**Subject: Gunlake Quarry Continuation Project (SSD-12469087) MOD 1  
Response to Modification Report**

## ATTACHMENT

### COMPONENT 1: Biodiversity Values of land identified as Area 1

Gunlake Quarry Continuation Project
Modification Report (MOD1)
Figure 3.1

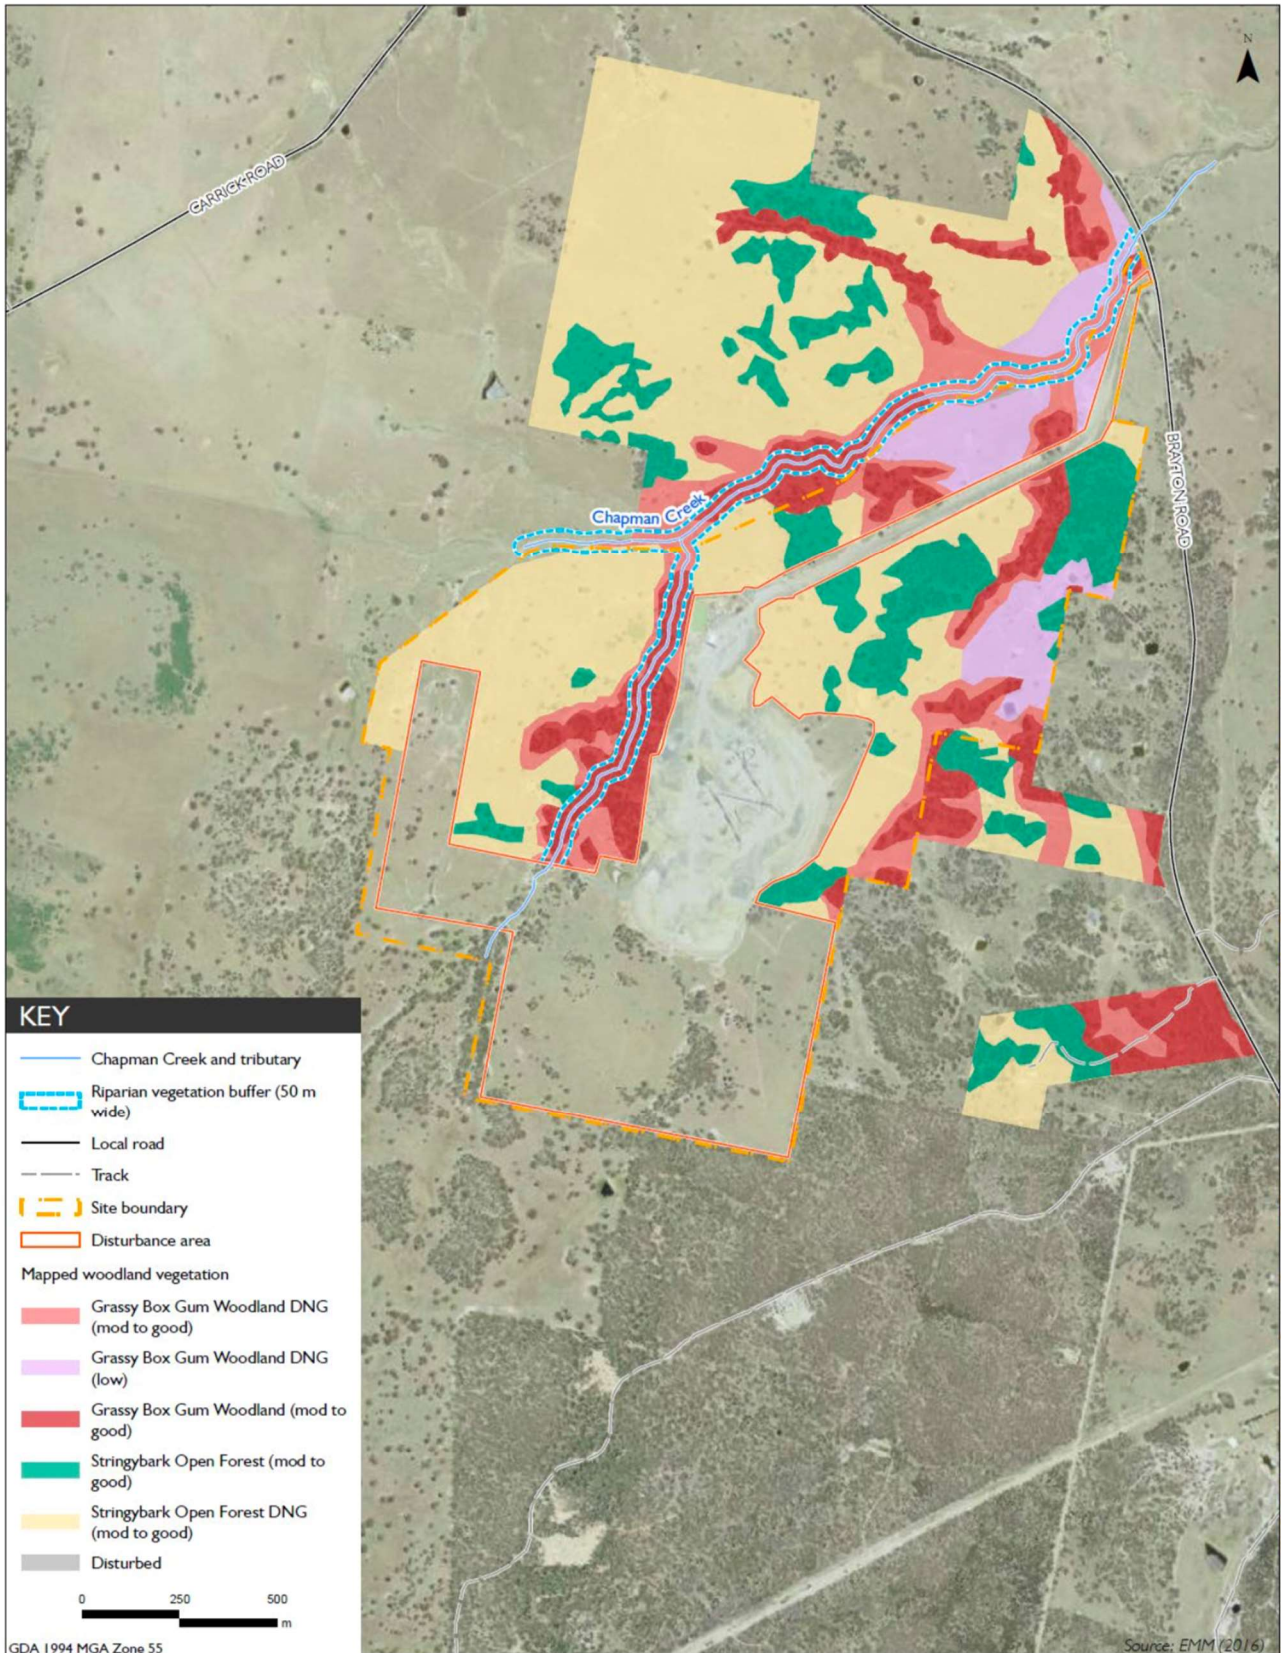
Based on the information provided, it is likely that the proposed revision will lead to a better environmental outcome and an improvement in biodiversity values of the site. This is contingent on the proposed Biodiversity Areas, as shown in Figure 3 of the report, being established and managed as a formal Biodiversity Stewardship Site.

As there is already a significant infestation of Serrated Tussock in the locality, it is important that the areas be managed appropriately, including development and implementation of a weed management program.

It is also essential that all fencing in and around the proposed conservation areas is wildlife friendly. There have been recent sightings of Koalas near the Marulan area, and there is therefore the likelihood of Koalas at times being present. Barbed wire fences are a significant hazard to Koalas (and other wildlife including bats and gliders) and it is strongly recommended that barbed wire must not be used in or adjacent to remnant woodland areas.
